STURTON BY STOW PARISH COUNCIL – WEST BURTON – additional submission open floor hearing 8th November 2023

Sturton by Stow parish council has the following additional points to raise.

SCALE: As Shown	DATE: 01.03.23	DRAWN: AC	CHECKED: RR	APPROVED: JD
JOB NO: 2107-061		DRAWING NO: Figure 5.3		REVISION: -

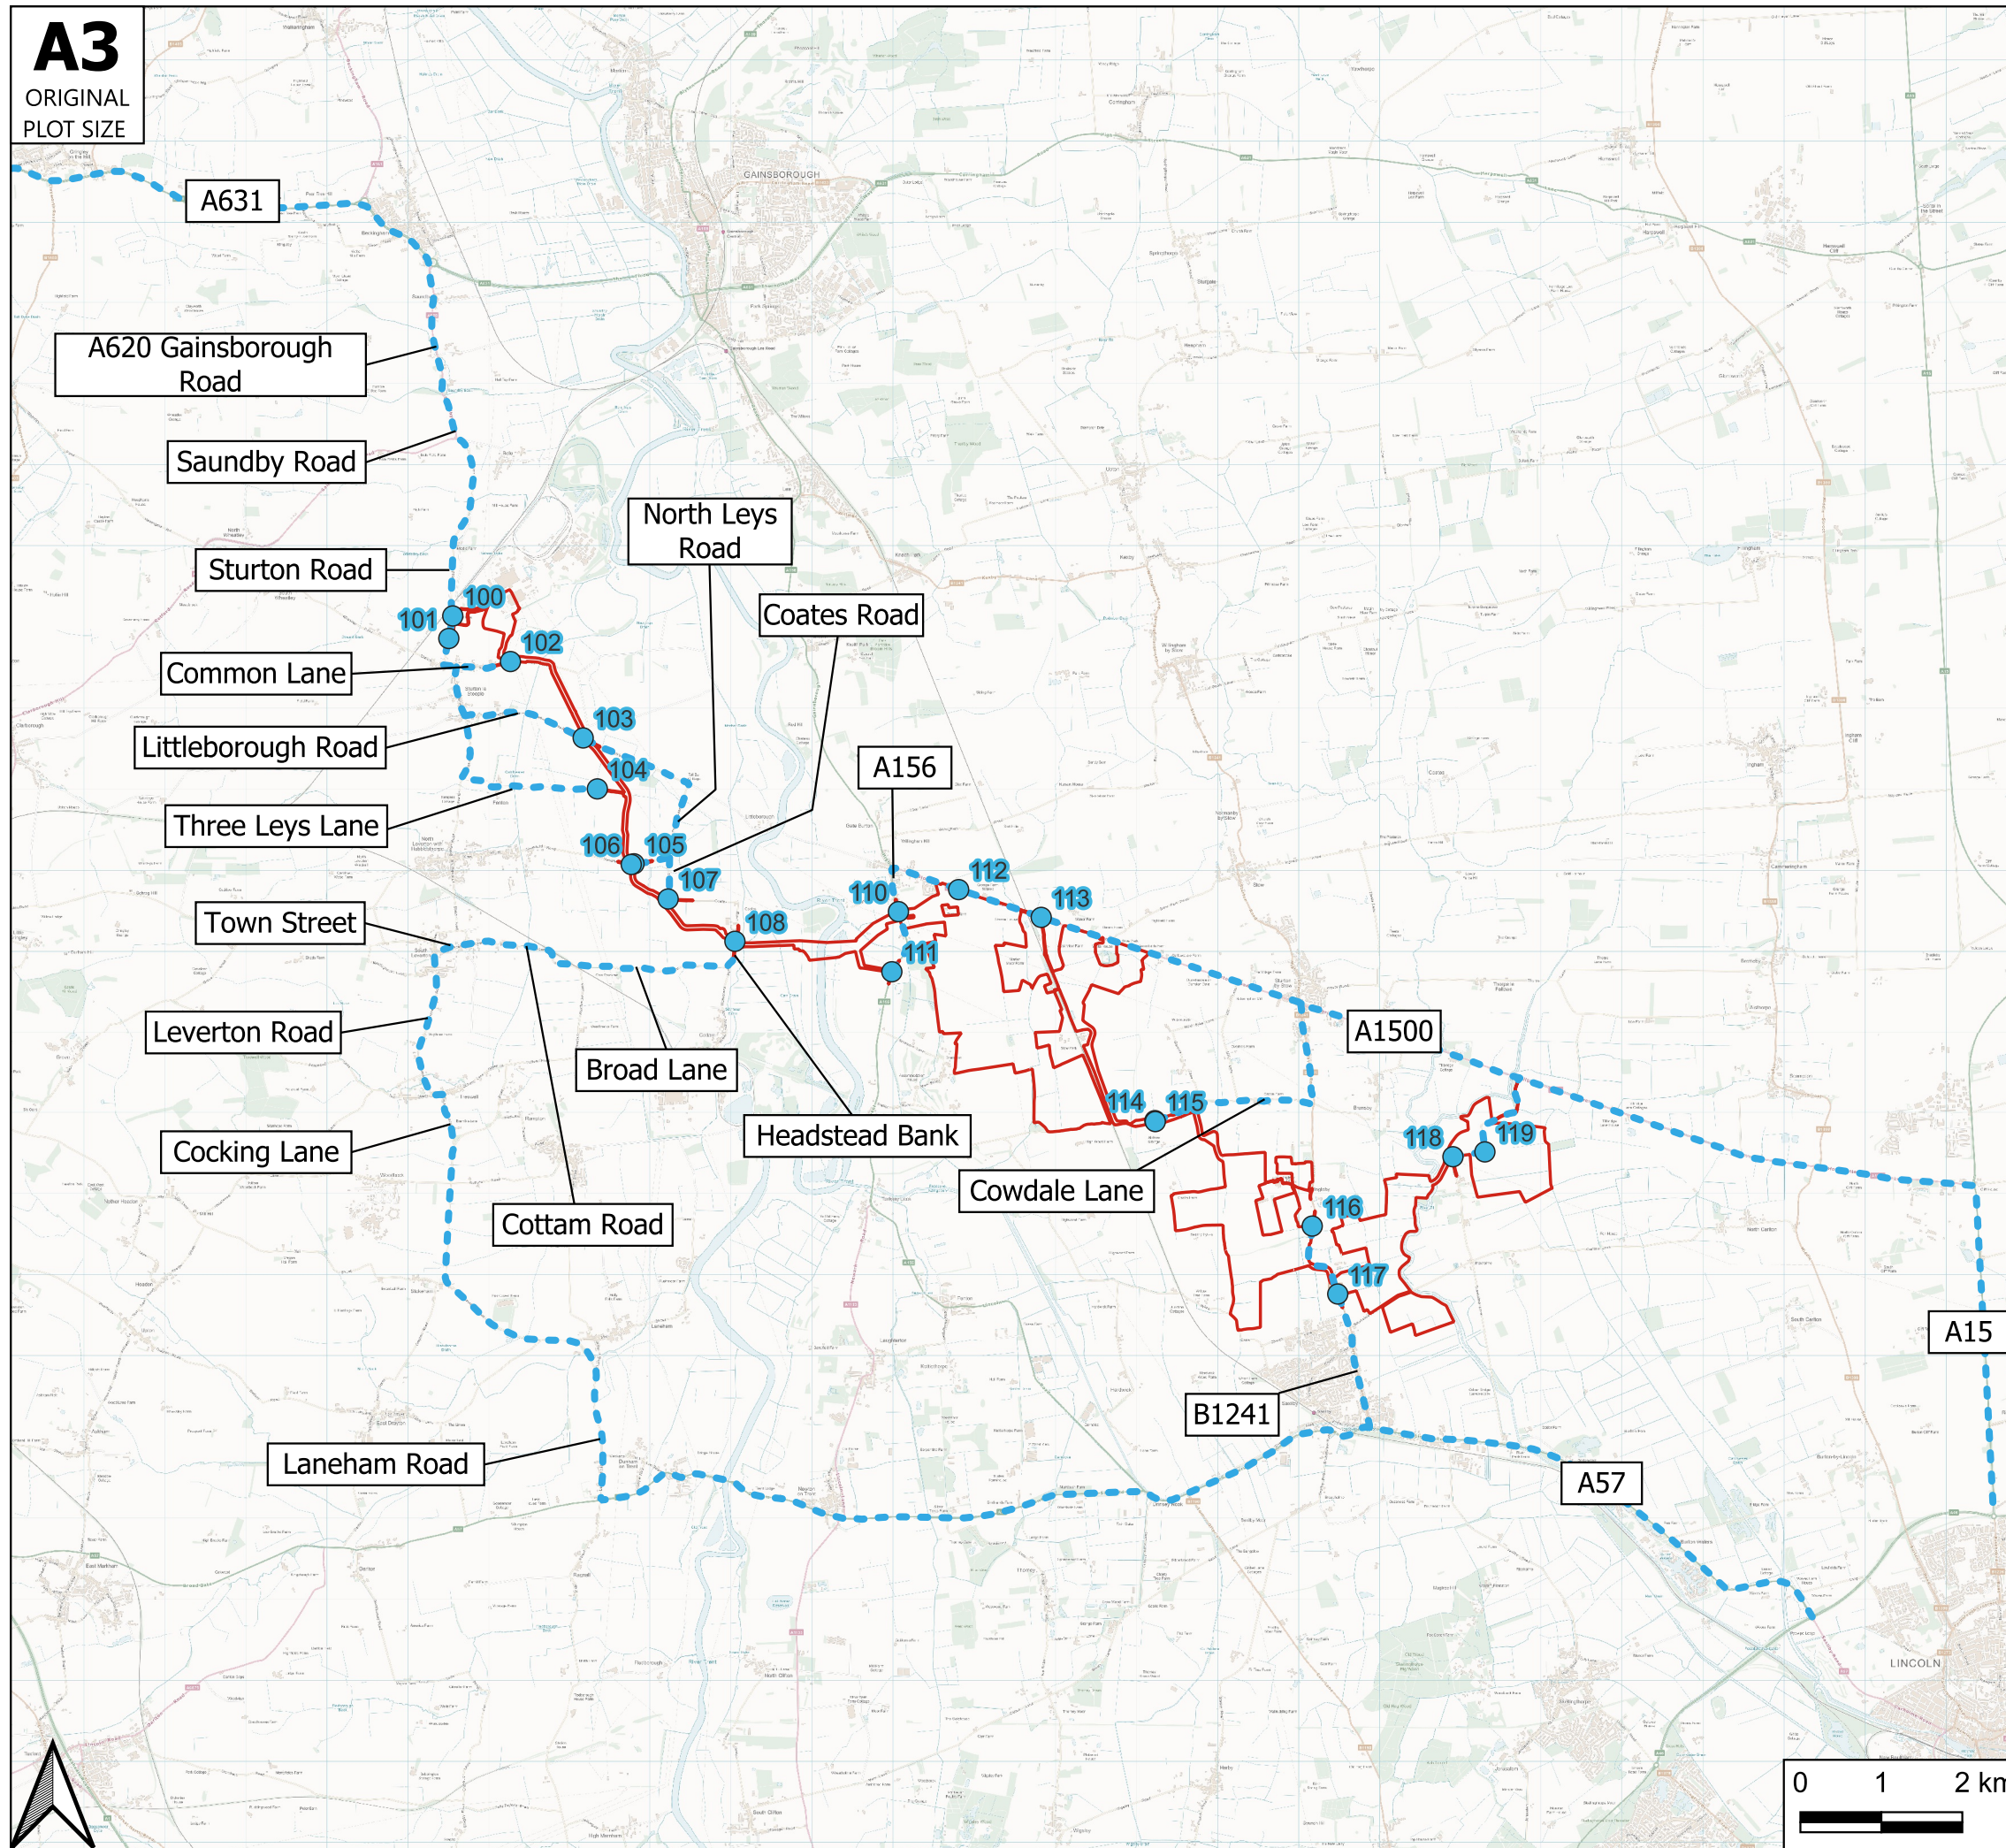
32. **App 14.2** Traffic Management – Figure 5.3 Construction Route 3. Grid connections 114 & 115 to Cowdale Lane. The same comment as note immediately above applies to this routing. In addition, the crossroads with Bransby (junction of B1241 and Cowdale Lane) This has had significant accidents in the past, some of which will fall outside of your 5-year review data. This crossroads is on a 60mph road and visibility is poor. Traffic management will be needed at this point. The crossroads was recently (Oct 2023) impassable due to floodwater.

B1241 Sturton Road Junction Arrangement

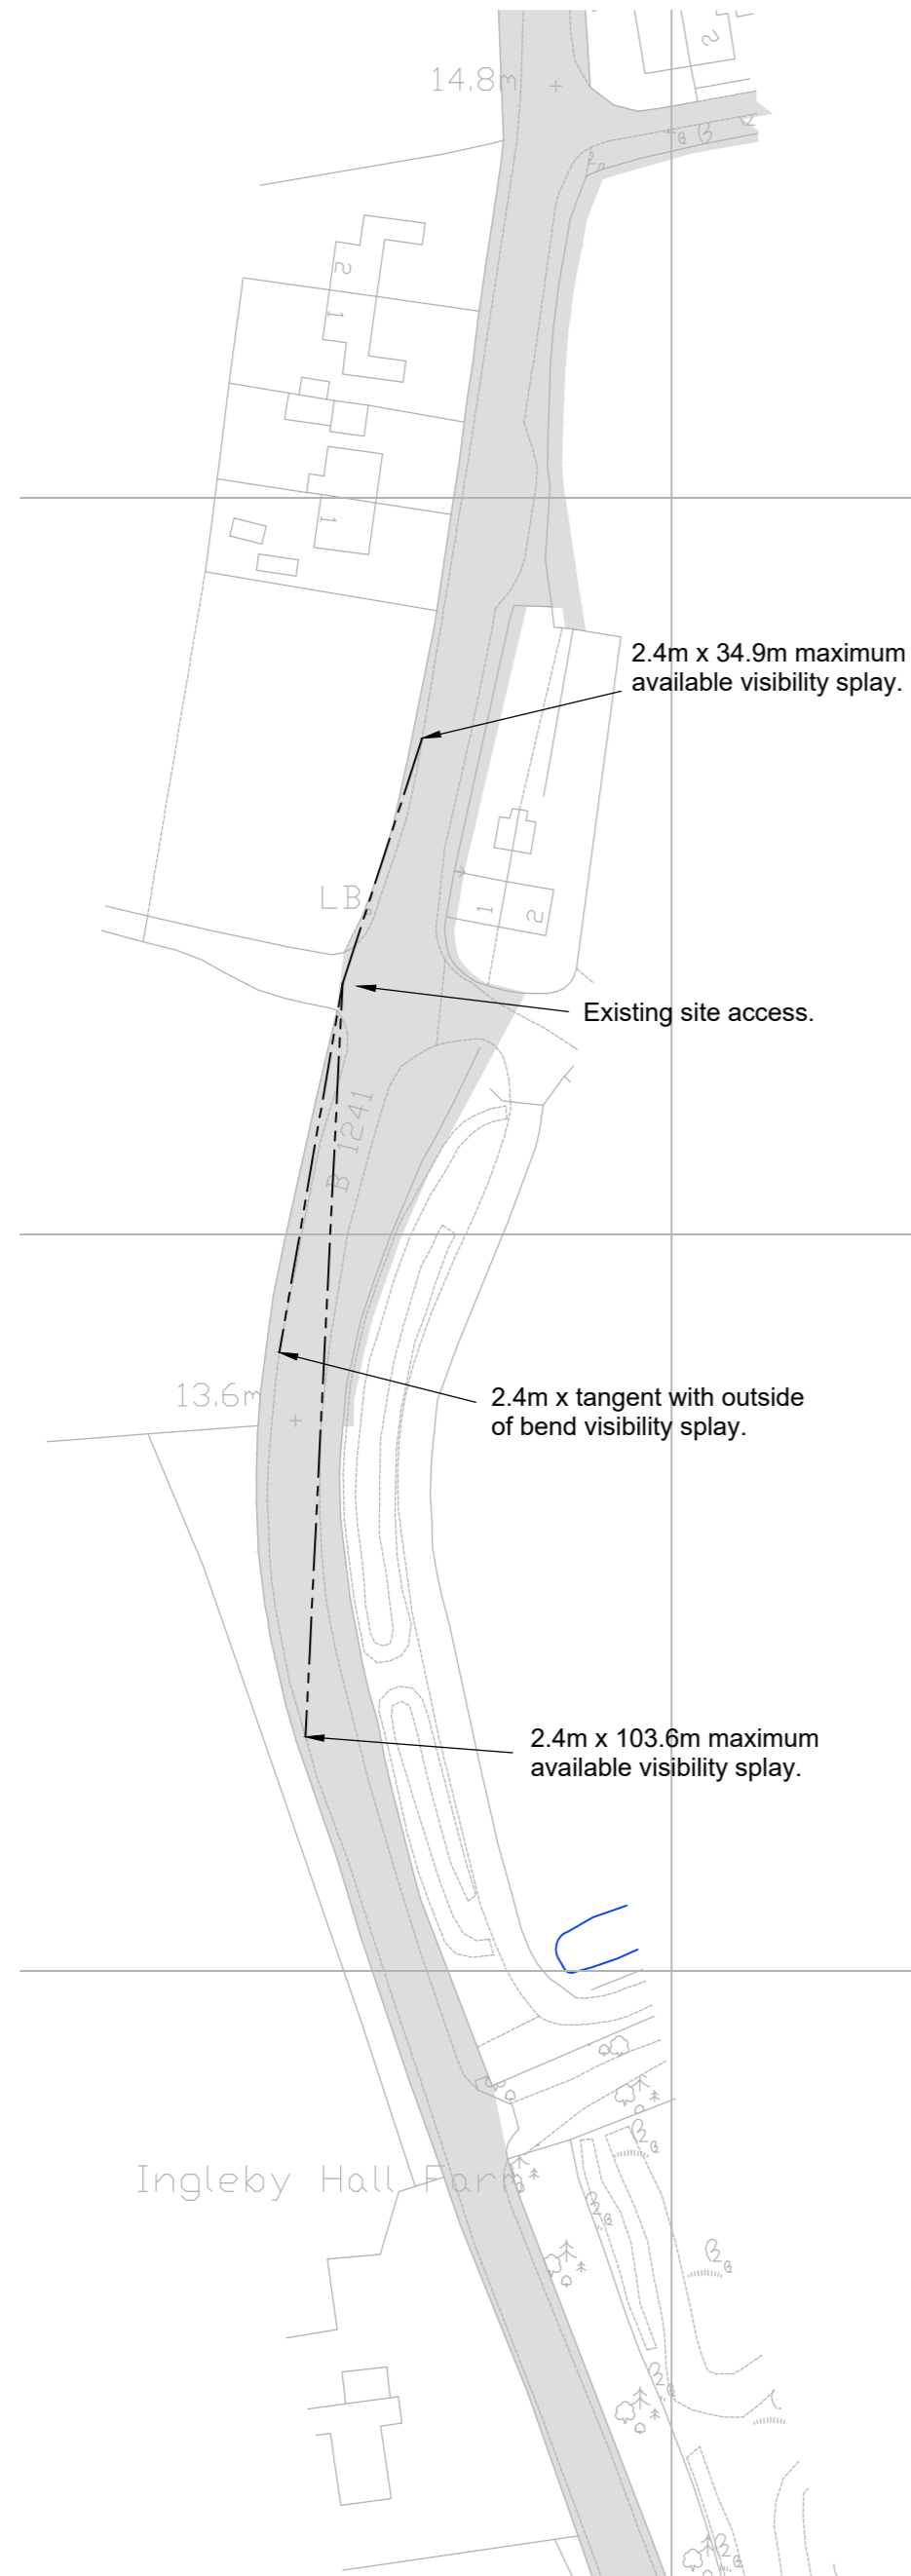
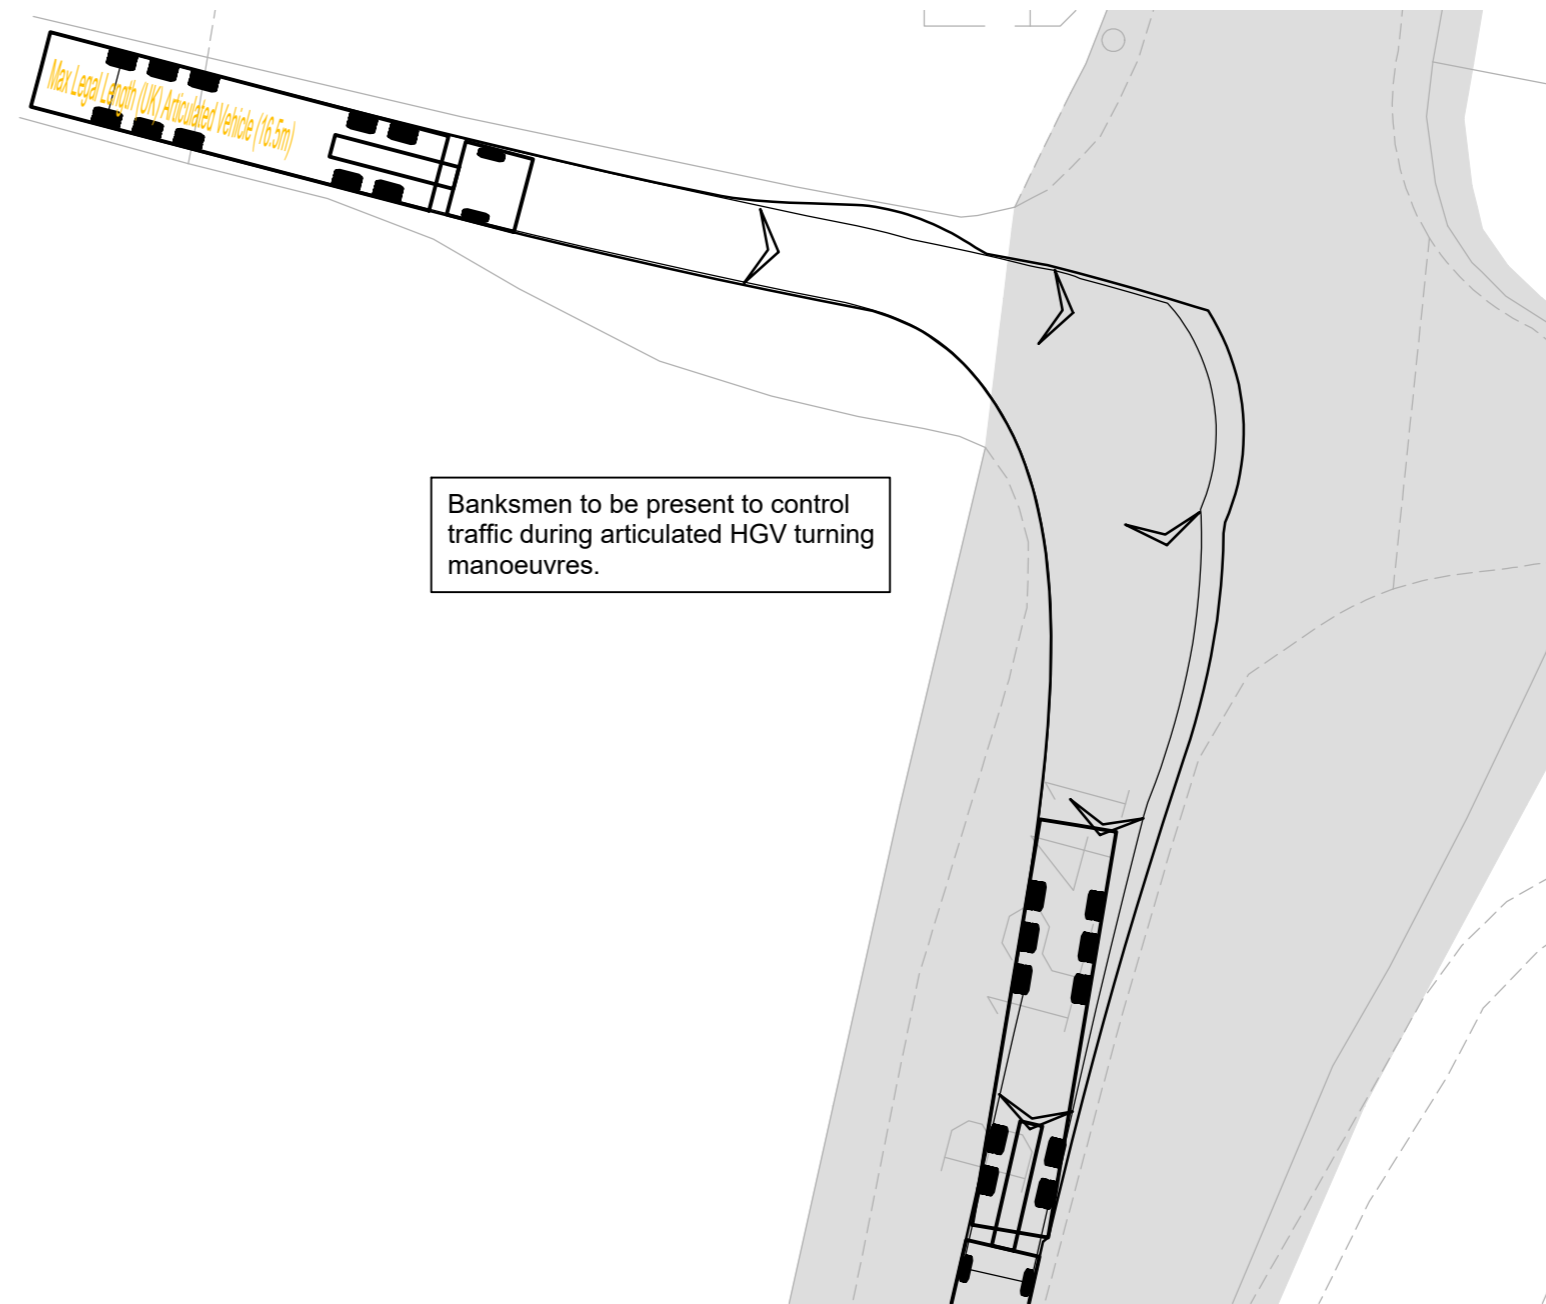
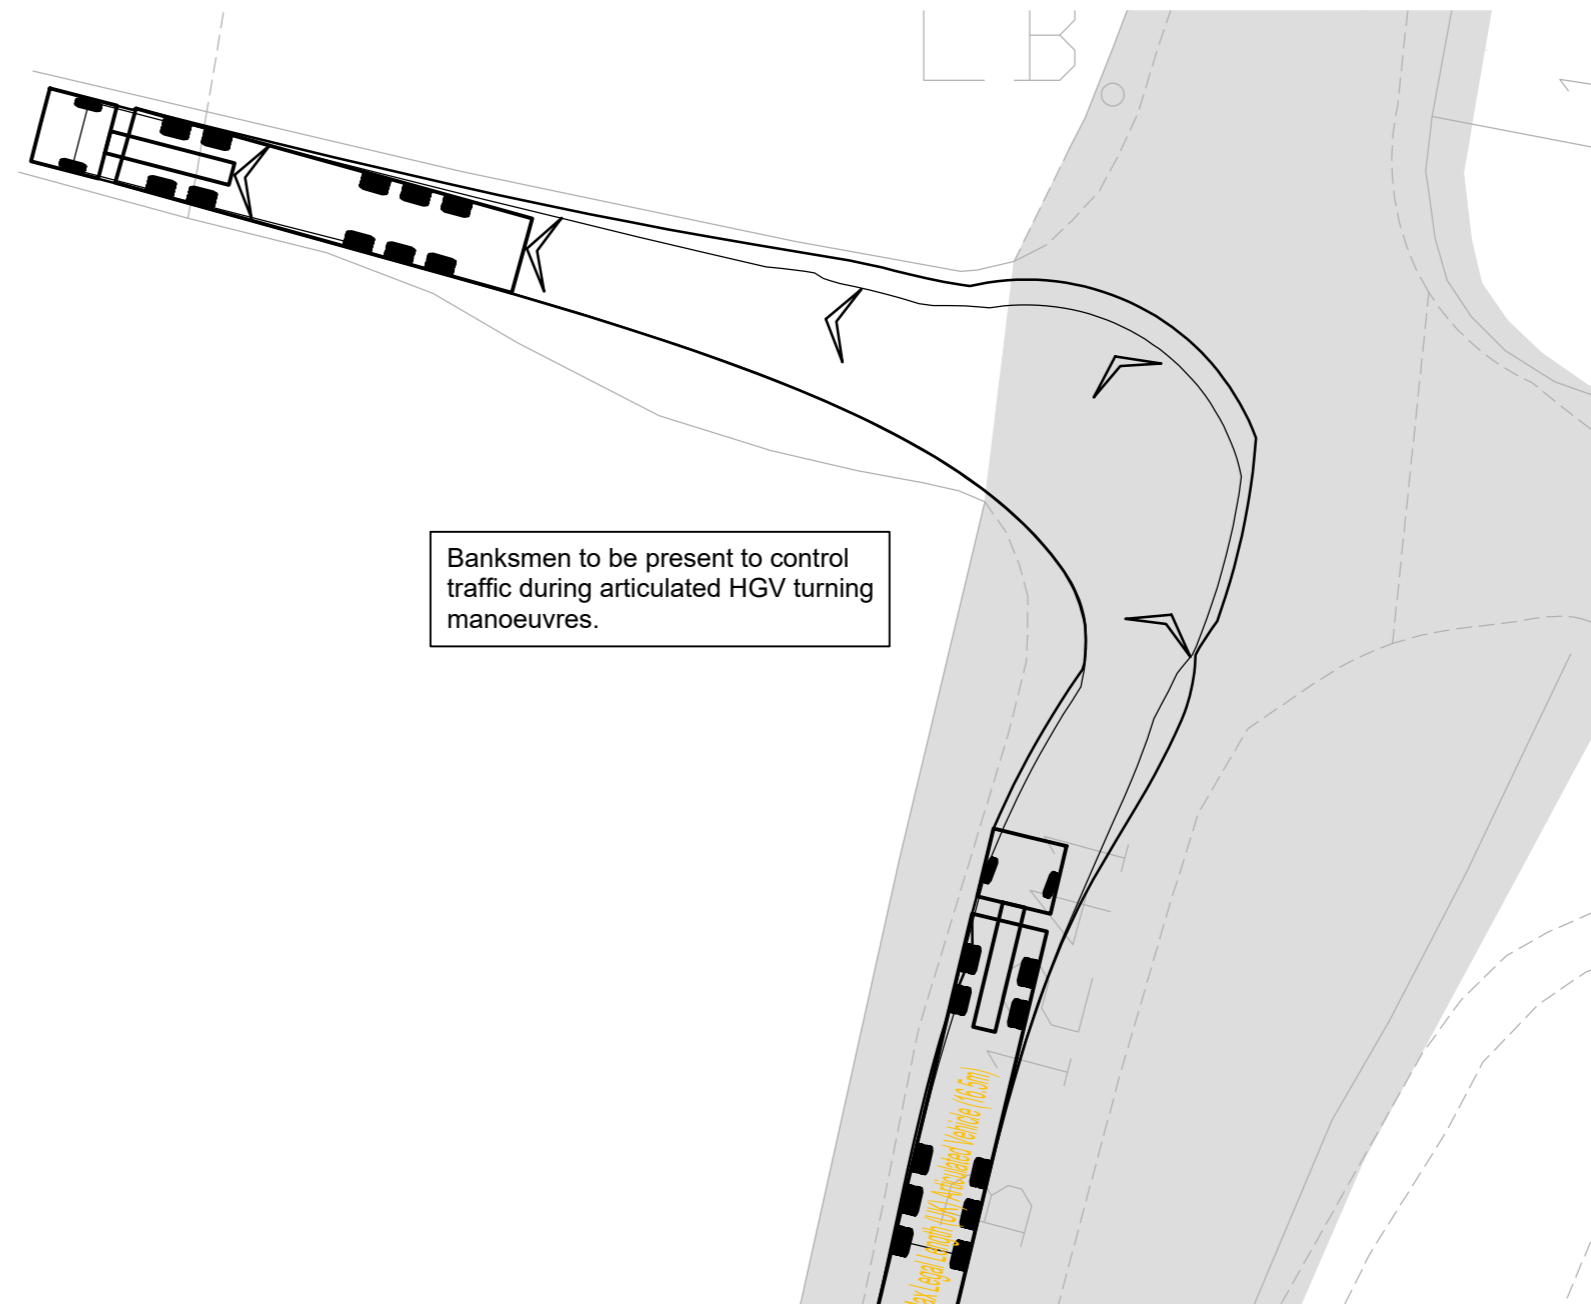
30. We specifically ask for B1241 to be looked at during the unaccompanied site visit. In Particular the junction with A1500 and B1241 – Tillbridge Road/Saxilby Road, Sturton by Stow.

31. The route specified in **Figure 5.1 of App 14.2** for West Burton 1 shows the use of A15, A1500 and B1241. Please make particular note that the junction of A1500 and B1241 (Saxilby Road) is narrow. The New Plough Public House has been struck many times by vehicles turning into Saxilby Road from A1500 (Eastern) Tillbridge Road. Particular care must be taken at this location. The footpath is extremely narrow and is used by pedestrians. Perhaps a different routing could be sought? Please note that A1500 at Tillbridge bridge was subject to major flooding in October 2023. In November 2019 the road was closed due to flooding for several days.

34. In the traffic document; **Chapter 14, Appendix 14.2** in respect of B1241 there are serious omissions. Abnormal routing for WB3 states A1500 → B1241. See comments above regarding this junction. There will be no option to widen any part of this junction. It is subject to buildings which obviously cannot be moved.
